From: Julie Grieves on behalf of Planning.Responses
Sent: 26 April 2012 08:14
To: Janice James
Subject: FW: Amendment to Notification re:FG/16/12/

Angmering Parish Council
Sent: 25 April 2012 13:10
To: Planning.Responses
Subject: RE: Amendment to Notification re:FG/16/12/

The following are the Parish Council comments on the additional documents submitted by ASDA:
1. Landscaping - Until the planting bordering the A.259 dual carriageway has established, suitable screening should be in place to an appropriate level to provide a light barrier from the headlights of cars maneuvering in this area.

Proposed Site Plan

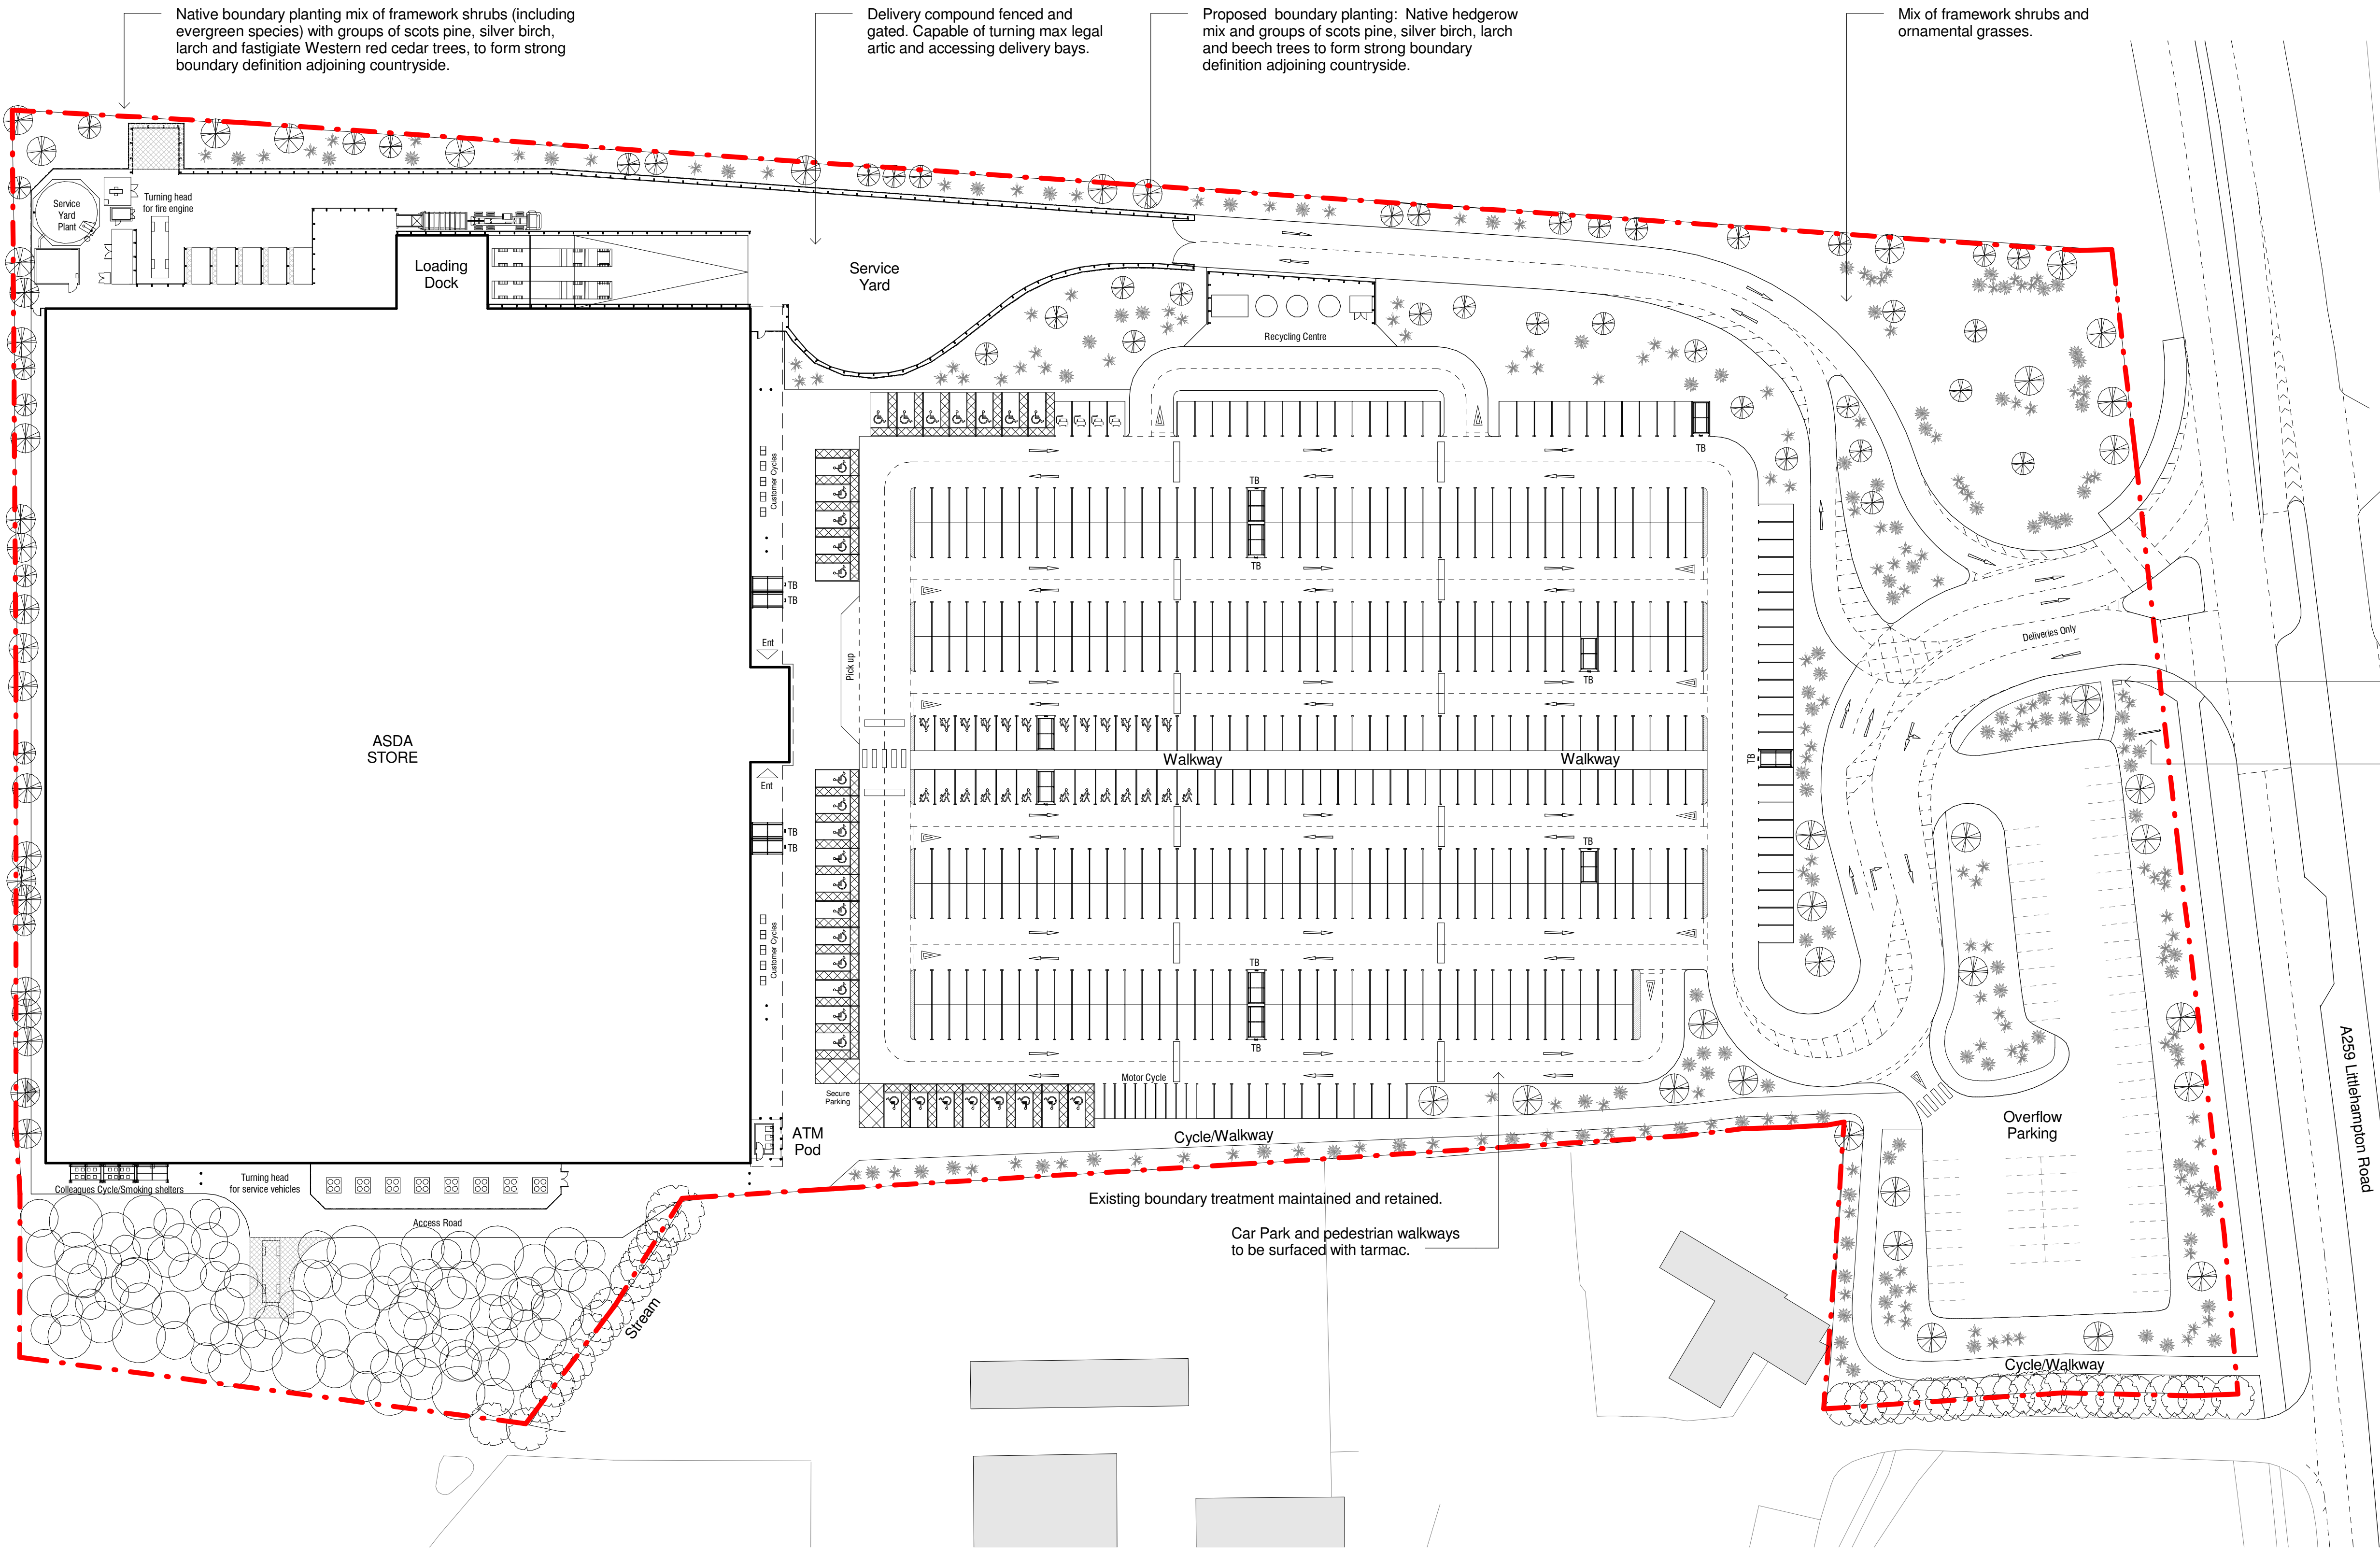
2. Lighting - Potential light pollution affecting the residential property adjacent to the car park which could have a detrimental effect on these neighbouring occupiers.

3. A further identified potential issue would be the impact of vehicle emissions on this adjoining property.
